CITY OF ALBUQUERQUE

June 24, 2022

**Re: San Pedro Apartments
San Pedro and Eagle Rock
Traffic Circulation Layout
Engineer's Stamp 06-21-2022 (C18-D108)**

CP-100

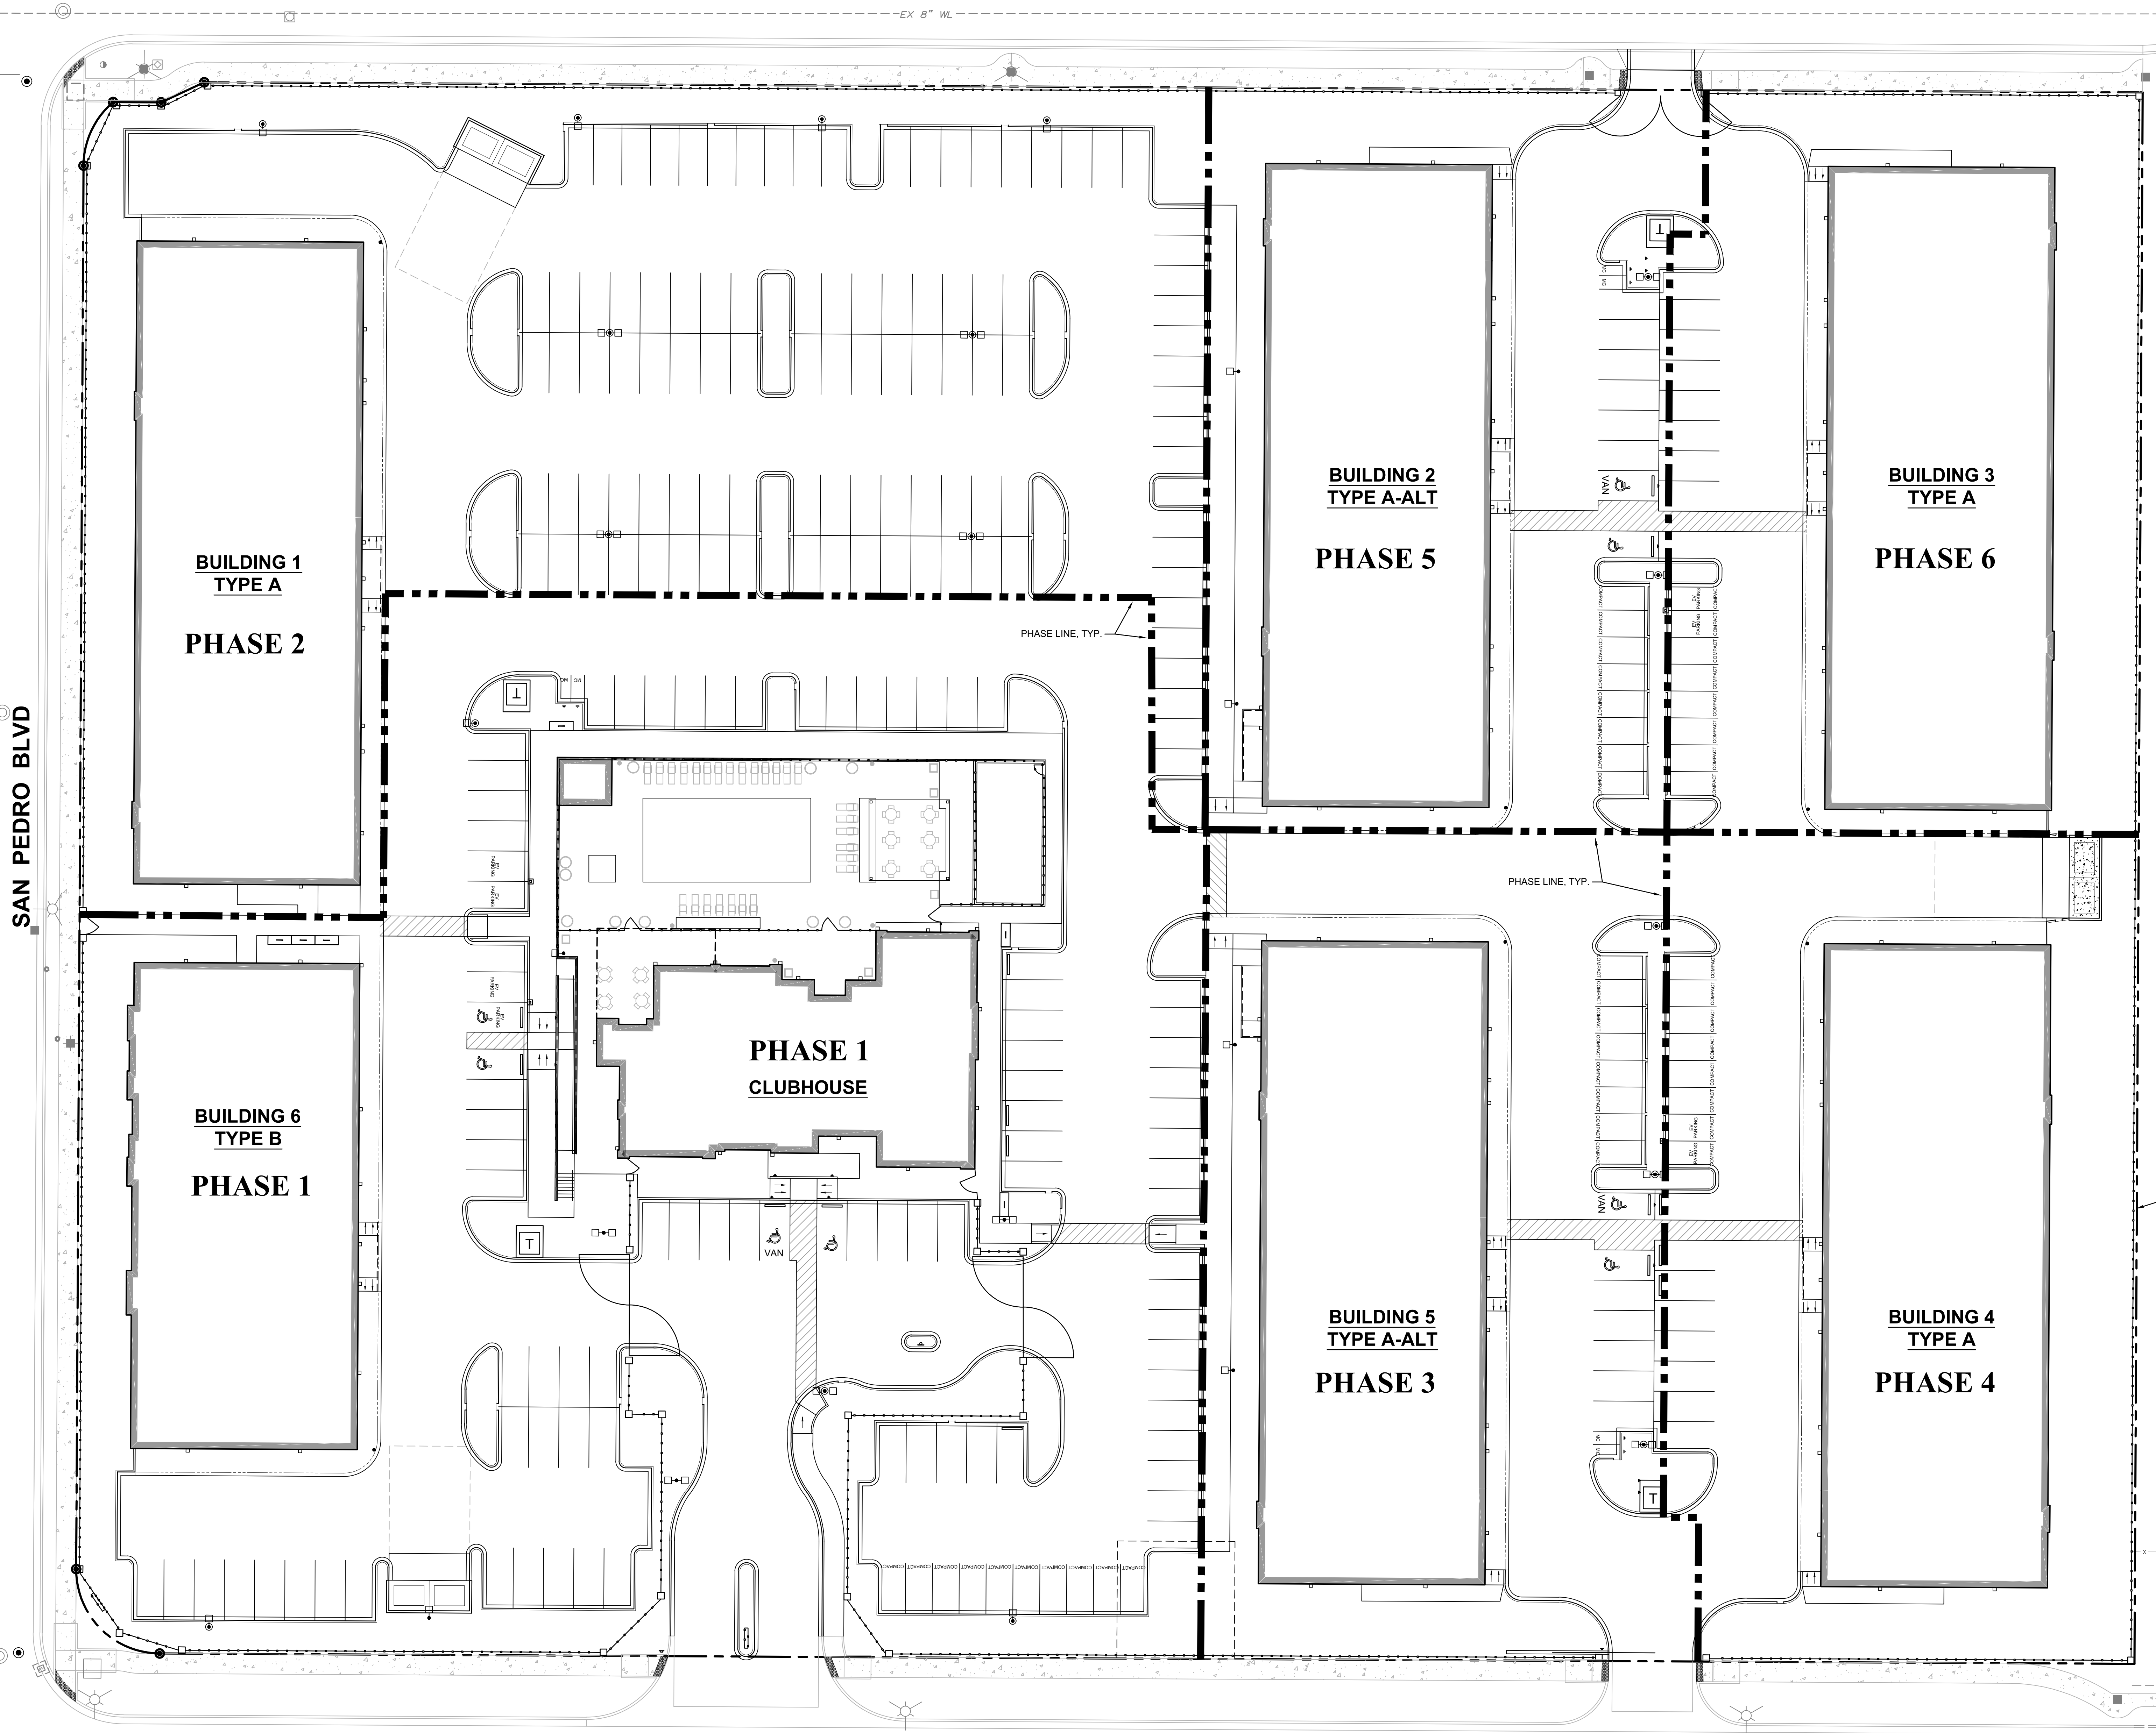
1. Keyed Note 21 (Section A-A):

- The section shows curbing across the entrance. This is considered a tripping hazard for ADA to traverse across the connection from the speed bump to the sidewalk .
- A second detail will need to be provide for section a-a to shown how this section function adjacent to Van access [(8' width with 6ft pathway next to it] aisle traversing onto sidewalk because 'ADA accessible pedestrian pathway should not be placed behind parking space or adjacent to a vehicular way. Vehicle and pedestrian/wheel chair conflicts should be avoided as much as possible.

2. Keyed Note 14 (ADA Parking Detail):

- Landing slopes should read 50:1 max in all directions.
 - Ramp Run slope should read 12:1 max with 2% cross slope.
3. **Keynote 20:** The key note detail reference (detail CD-502) within Public ROW conflicts with COA std dwg 2426 ramp detail. Please address.

4. The ADA accessible parking sign must have the required language per 66-7-352.4C NMSA 1978 **"Violators Are Subject to a Fine and/or Towing."** Please call out detail and location of signs. **This has been addressed on detail Sheet CD-502**

- a. The bicycle frame shall be supported horizontally at two or more places.
5. All sidewalks along streets should be placed at the property line. **For any sidewalk obstruction, please review COA std dwg 2431 & 2432.**
